SUBJECT: **BRES2507-0048**
BUILDING RESIDENTIAL

Here are the results of all Inspections located at **51 OXFORD WOODS DR:**

NOTES & DRAWINGS

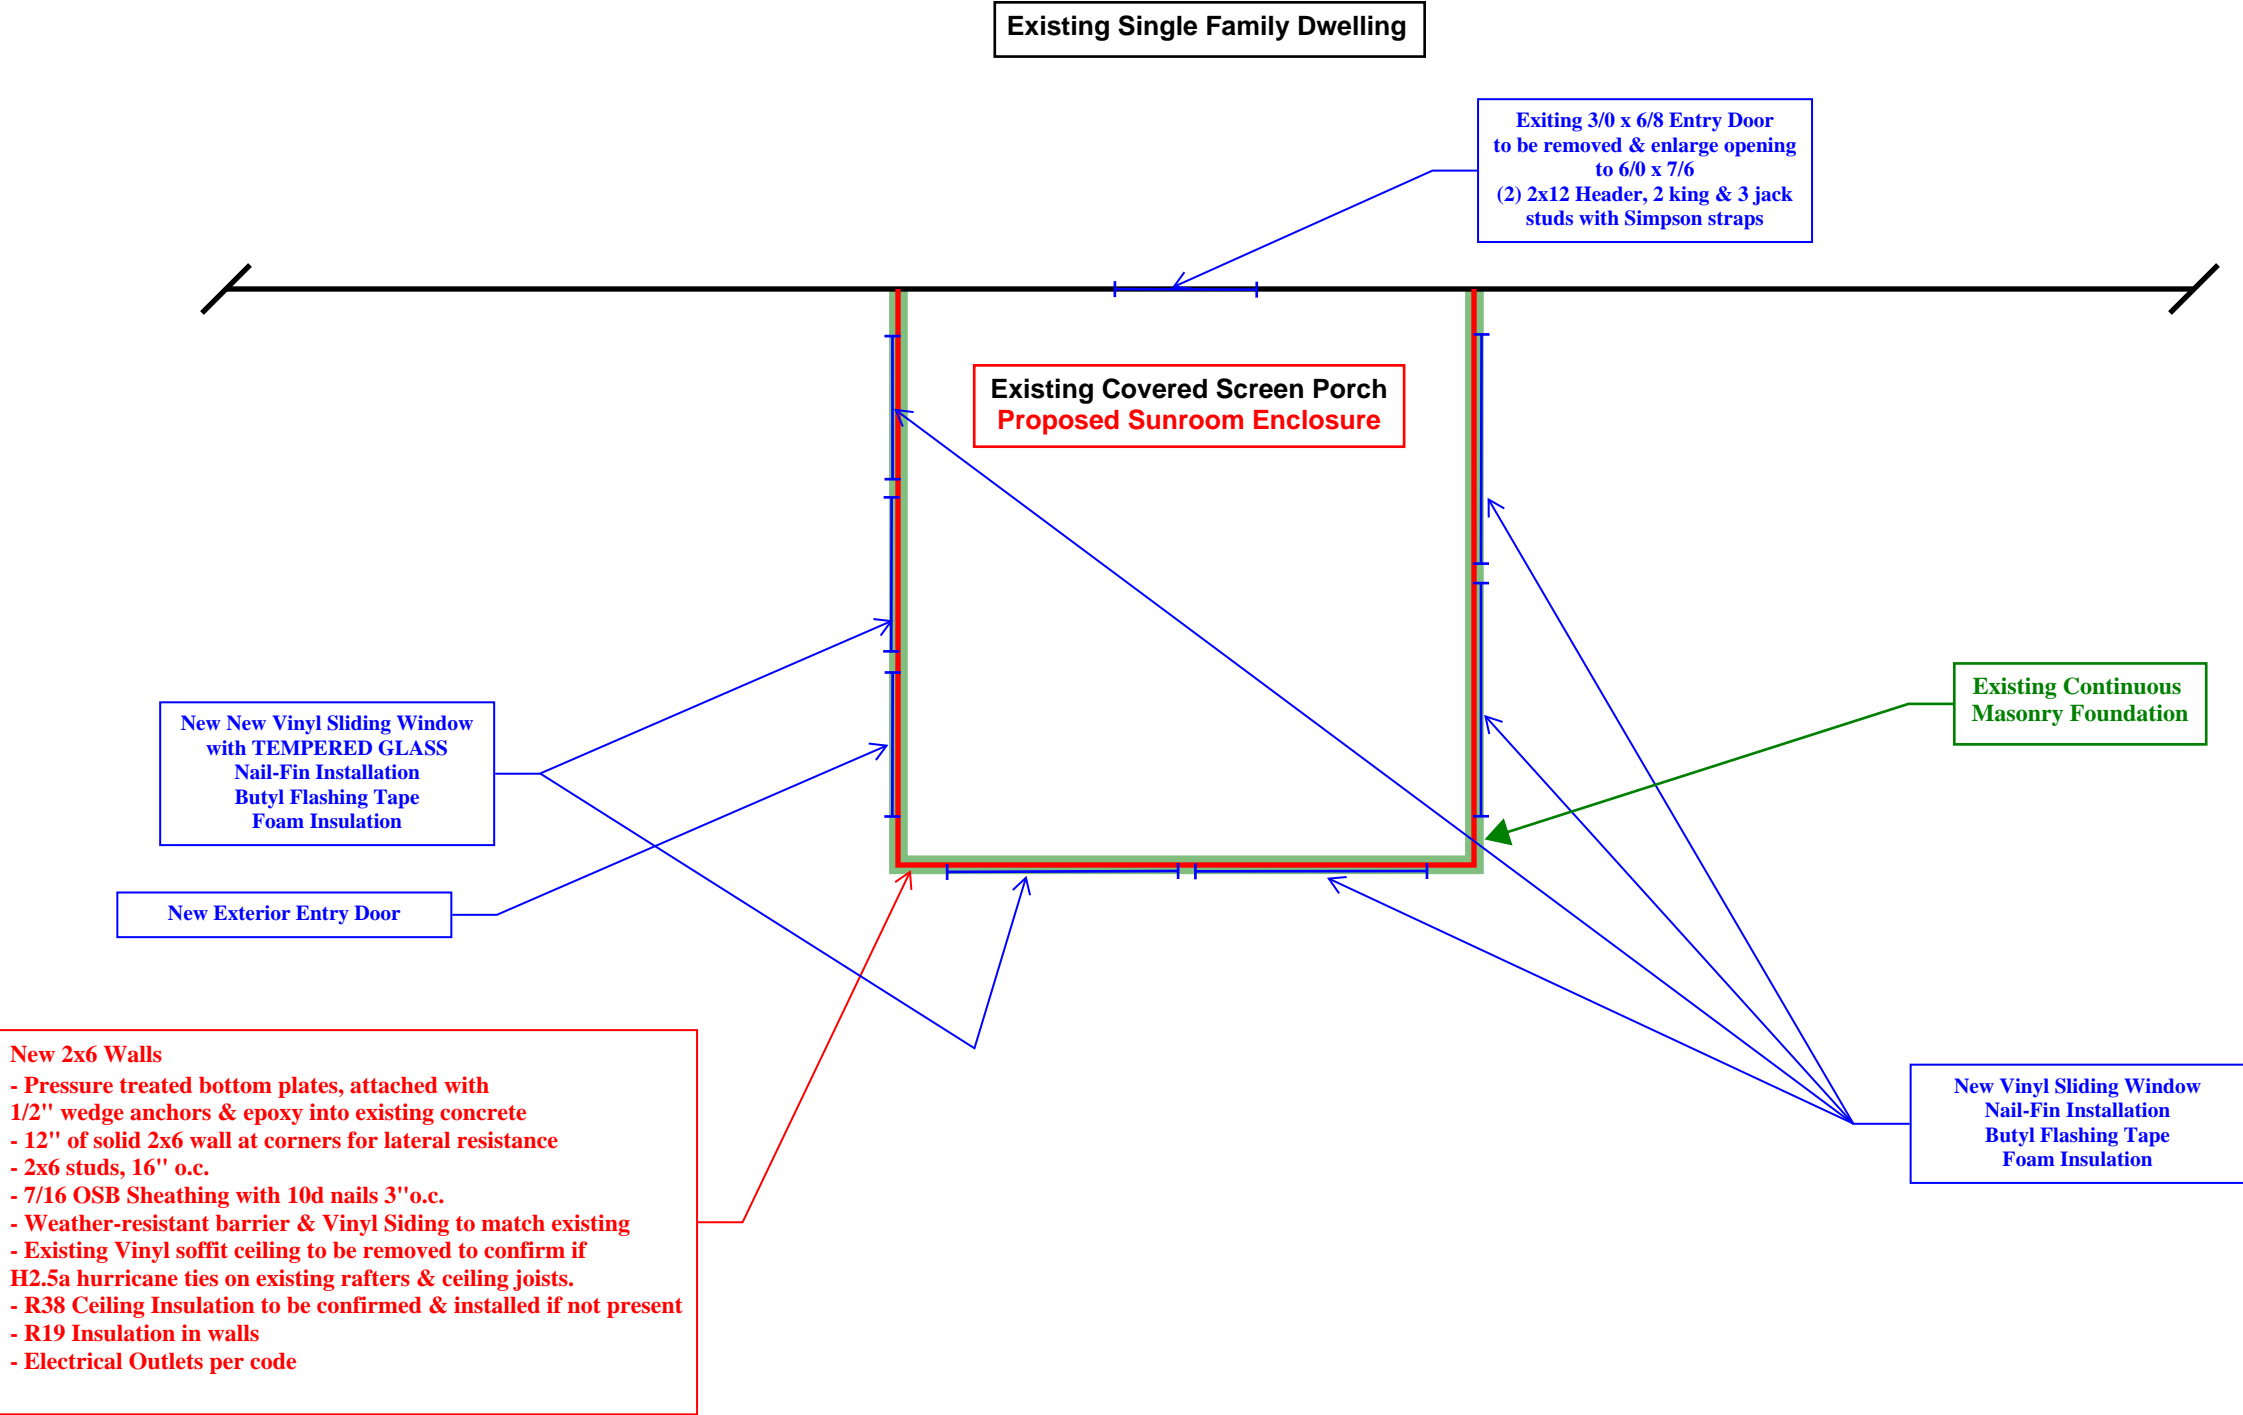
Inspection Type: ROUGH IN
Scheduled Date/Time: 9/26/2025
Completed Date/Time: 9/26/2025
Inspector: Brad Sutton
Result: DISAPPROVED
Remarks:
Notes: Anchor bolts missing at wall on door side. Ok to insulate. leave insulation up to see anchor bolts

Gaps in insulation present throughout walls and ceiling, entire thermal envelope must be completely and securely insulated.
